From: Thomas Callaway
Sent: 05 October 2016 14:54
To: Planning.Responses
Subject: RE: Planning Consultation on BR/214/16/DOC

APPLICATION NO: BR/214/16/DOC

Site Address: University of Chichester Upper Bognor Road Bognor Regis
PO21 1HR

Description of Works: Application for approval of details reserved by condition imposed under BR/54/16/PL relating to condition No. 7 (Construction management plan), 10 (Surface water drainage), 12 (Watercourse), 14 (External lighting scheme), 15 (Noise), 16 (Public sewers), 17 (Foul & surface water sewerage disposal), 18 (Cars), 19 (Roof plant), 23 (Landscaping scheme), 24 (Tree retention & protection plan), 25 (Programme of archaeological work & scheme of investigation), 26 (schedule of materials) & 34 (Programme of ecological work)

TITLE: PRELIMINARY FOUL DRAINAGE FOR COSTING

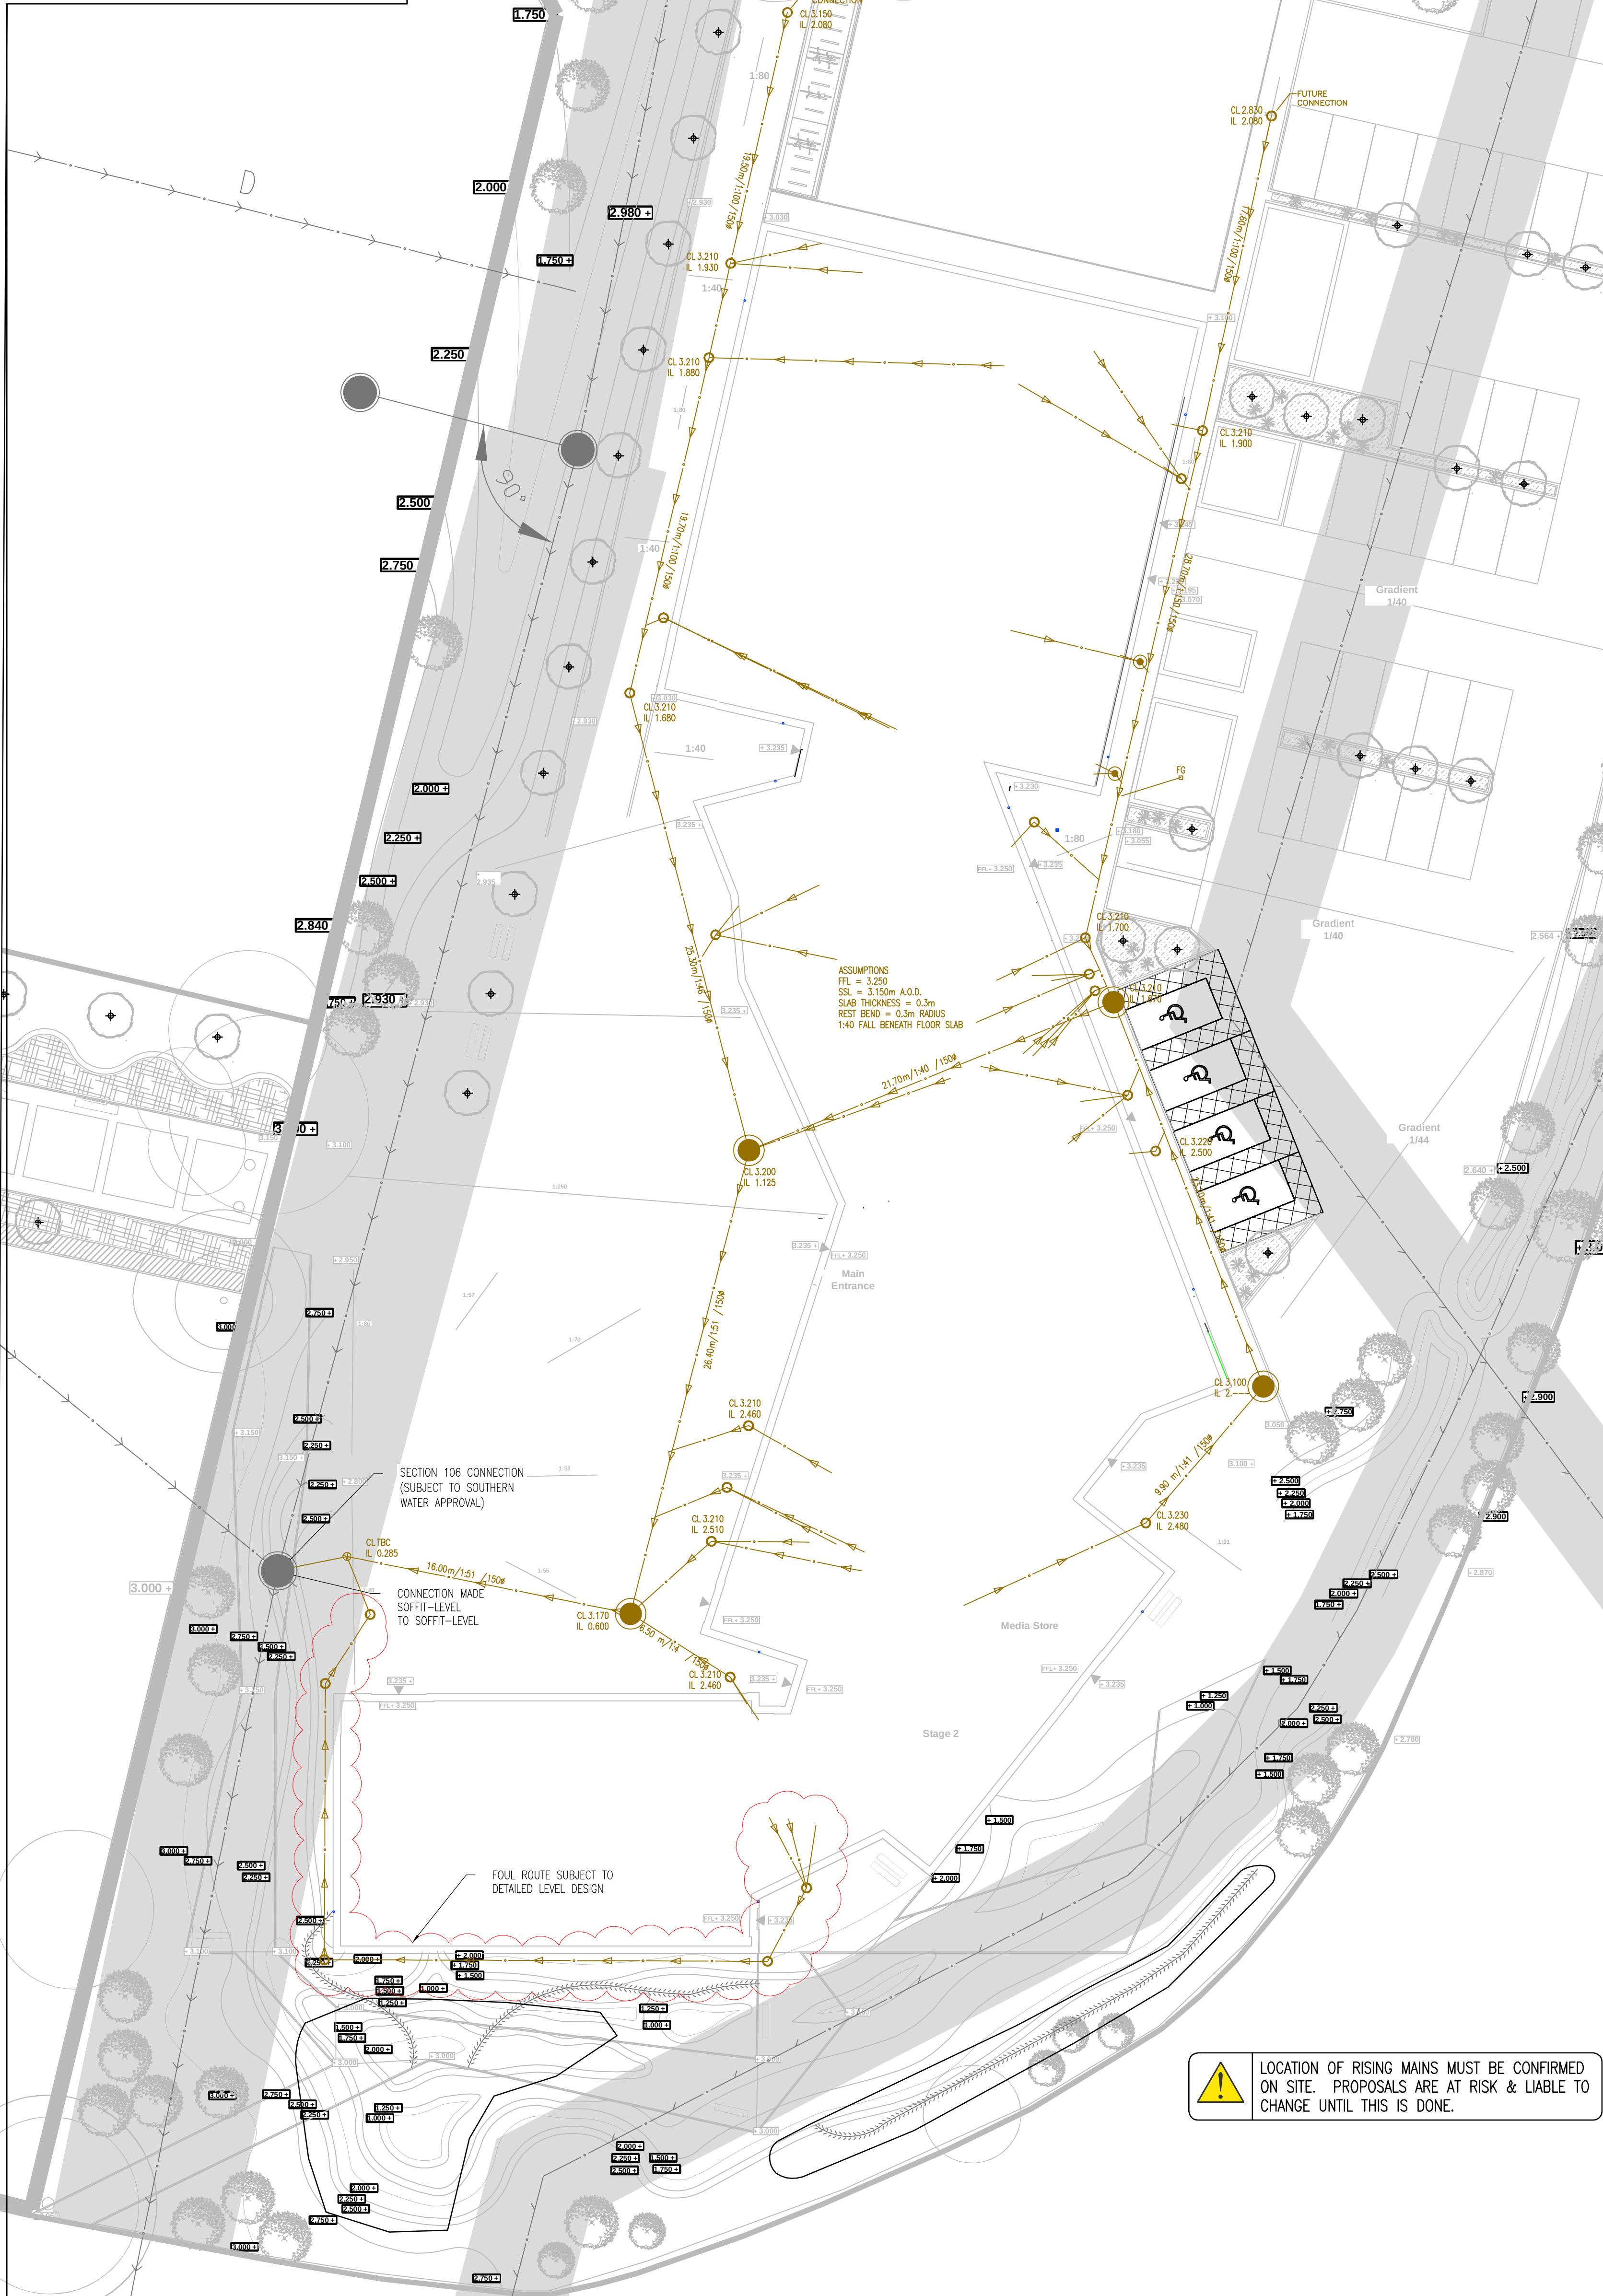
We have concerns over notes on the drawings stating that rising main positions are still not confirmed. Also notes on parts of the proposed surface water drainage system stating that features are subject to detailed design. The DOC submission must be at the detailed design stage to be approved.
